Office of Environment & Heritage

Our Ref: DOC17/176111
Your Ref: MP 09-0228 MOD 4

Re: North Byron Parklands, Cultural Events Site Major Project (MP) 09-0028 Modification 4.

Plan **EA 1.3**
**Revised Ecological
Structure Plan**
North Byron Parklands | Tweed Valley Way & Jones Road

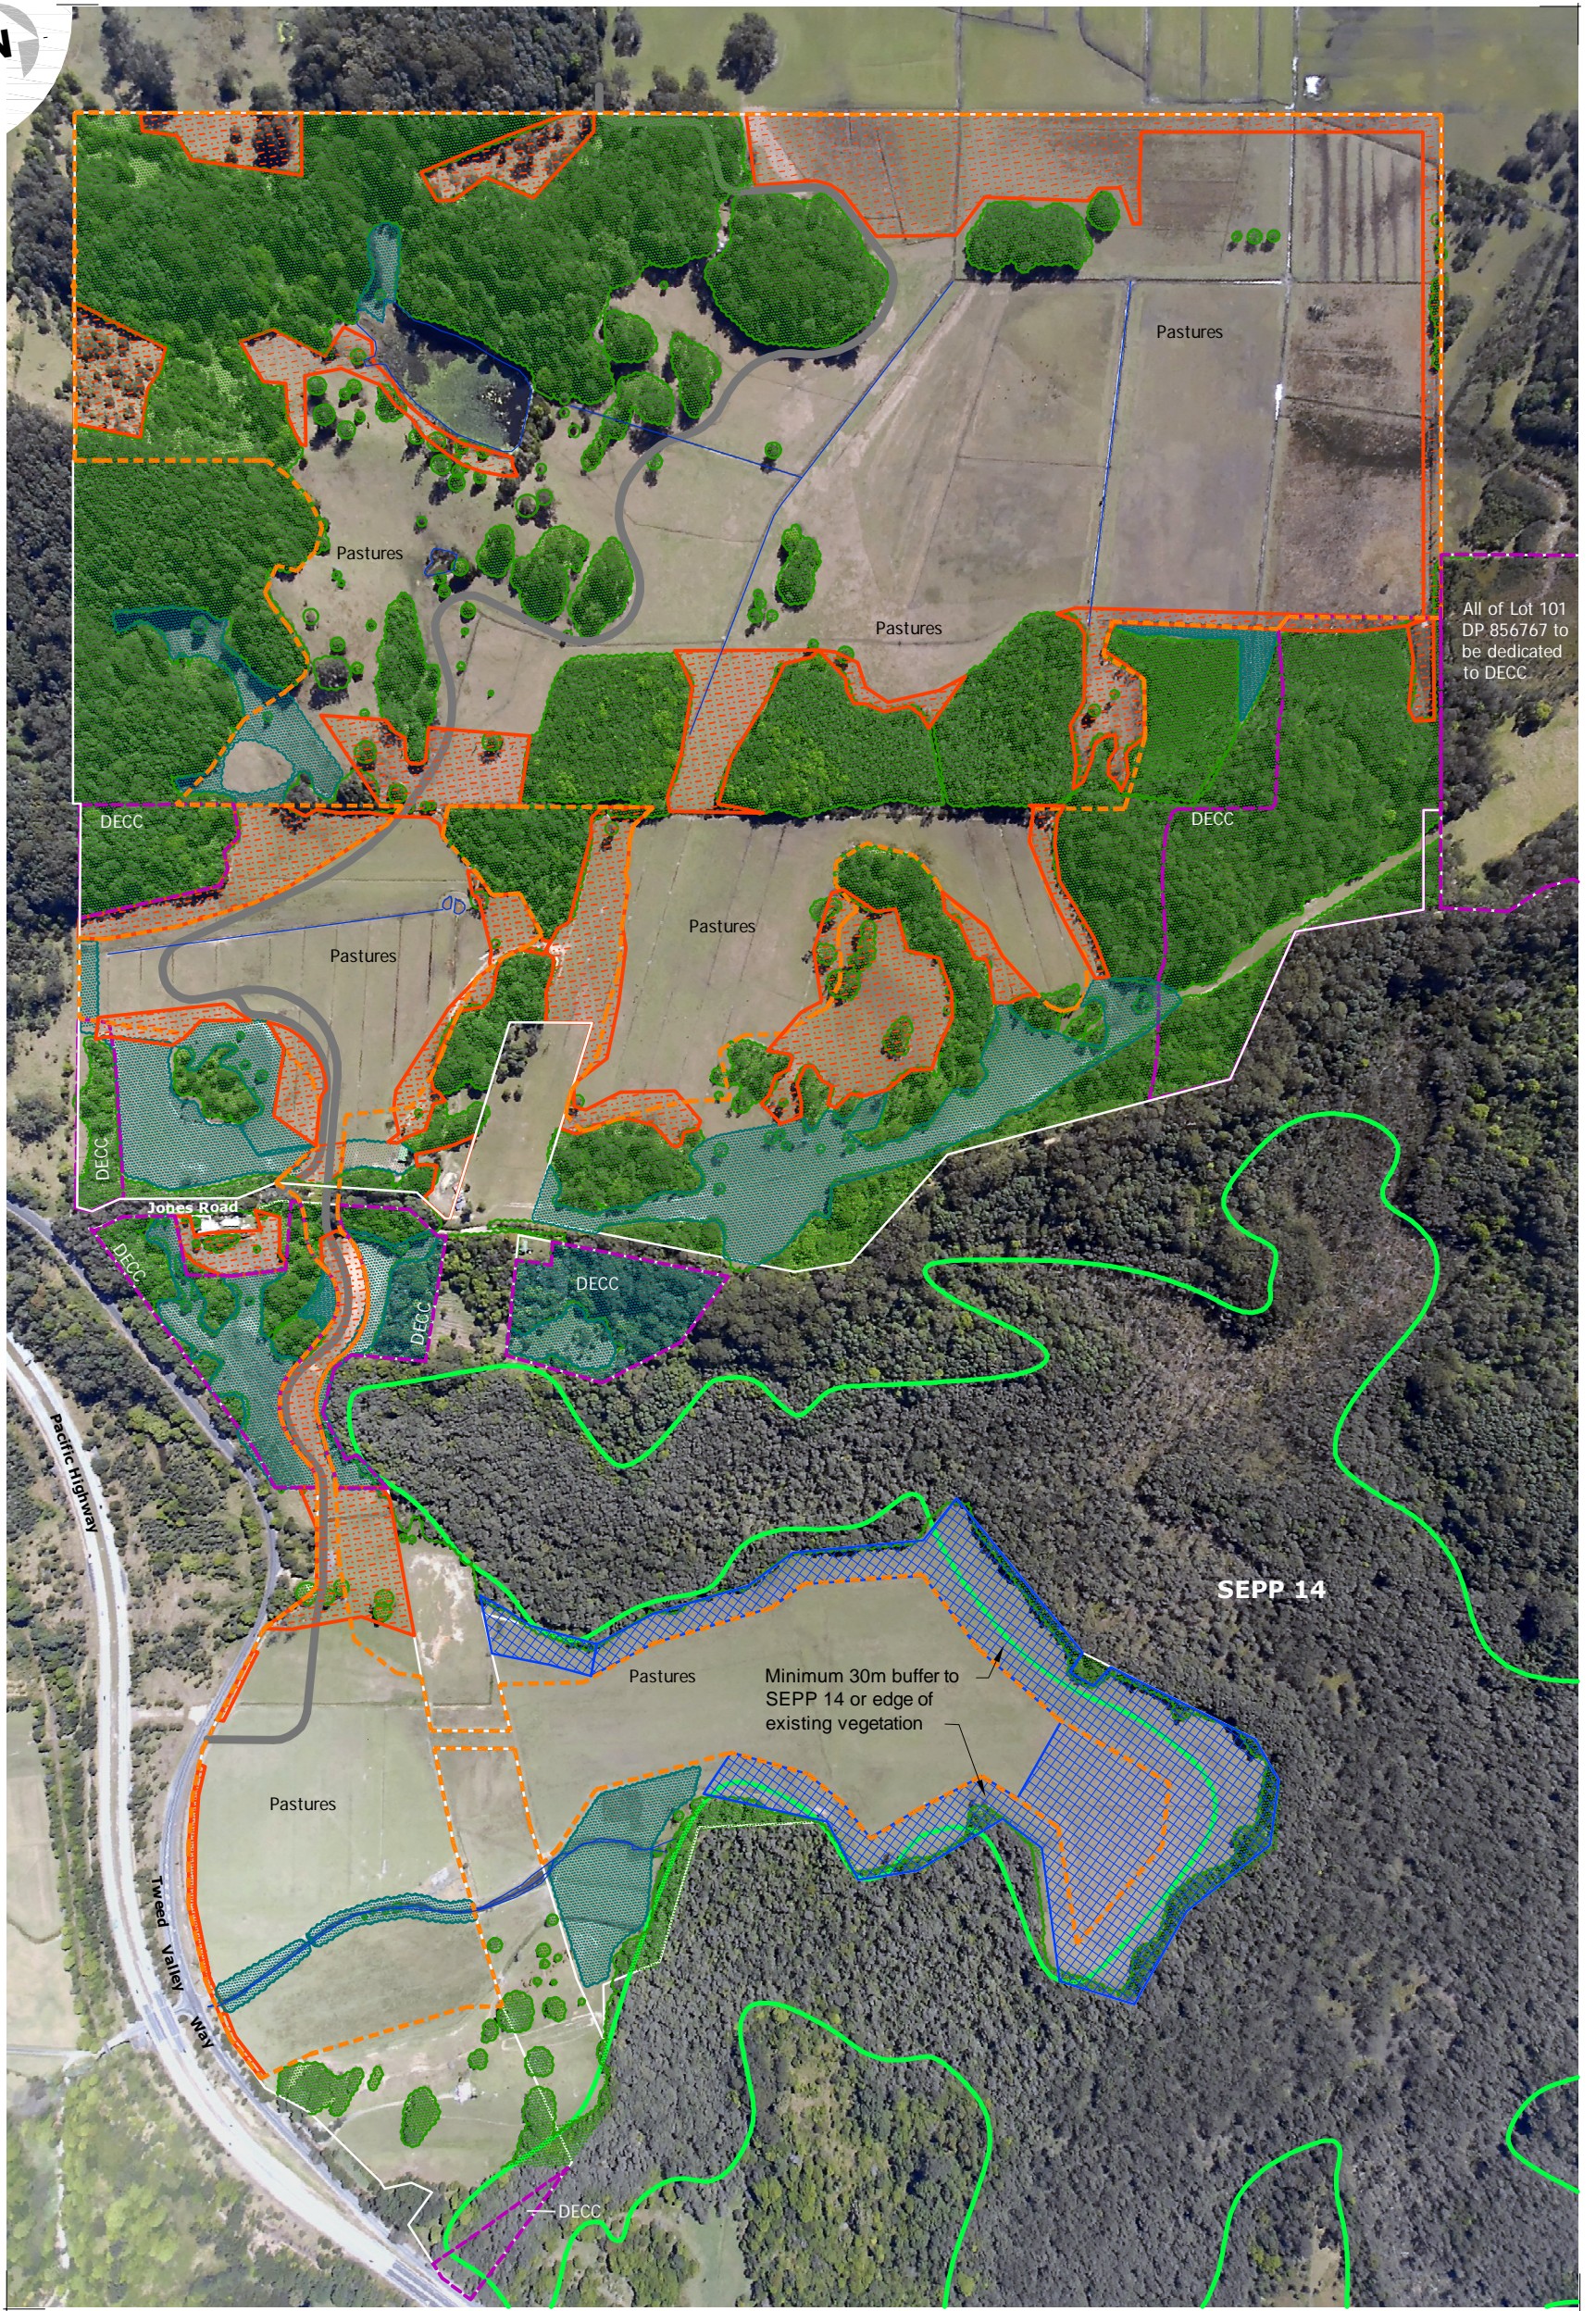
- a. identify and map all the lands depicted on Figure 7 "land to be dedicated to DECC" of the revised Ecological Structure Plan approved by the Department of Planning and Environment and show land parcels as either Stage 1 (land-swap) or Stage 2 (land-dedication).

2. Revise the North Byron Parklands Flora and Fauna Rehabilitation Program to:
 - a. deliver on the 12.9 hectares of proposed new habitat under the Ecological Structure Plan to provide the buffer to Billinudgel Nature Reserve and the SEPP 14 Wetlands.

- b. define and map the preferred plant community type(s) to be created over the site in consultation with OEH.
 - c. provide performance based actions, include a staged approach to the rehabilitation of the site if required to achieve the preferred plant community type(s).
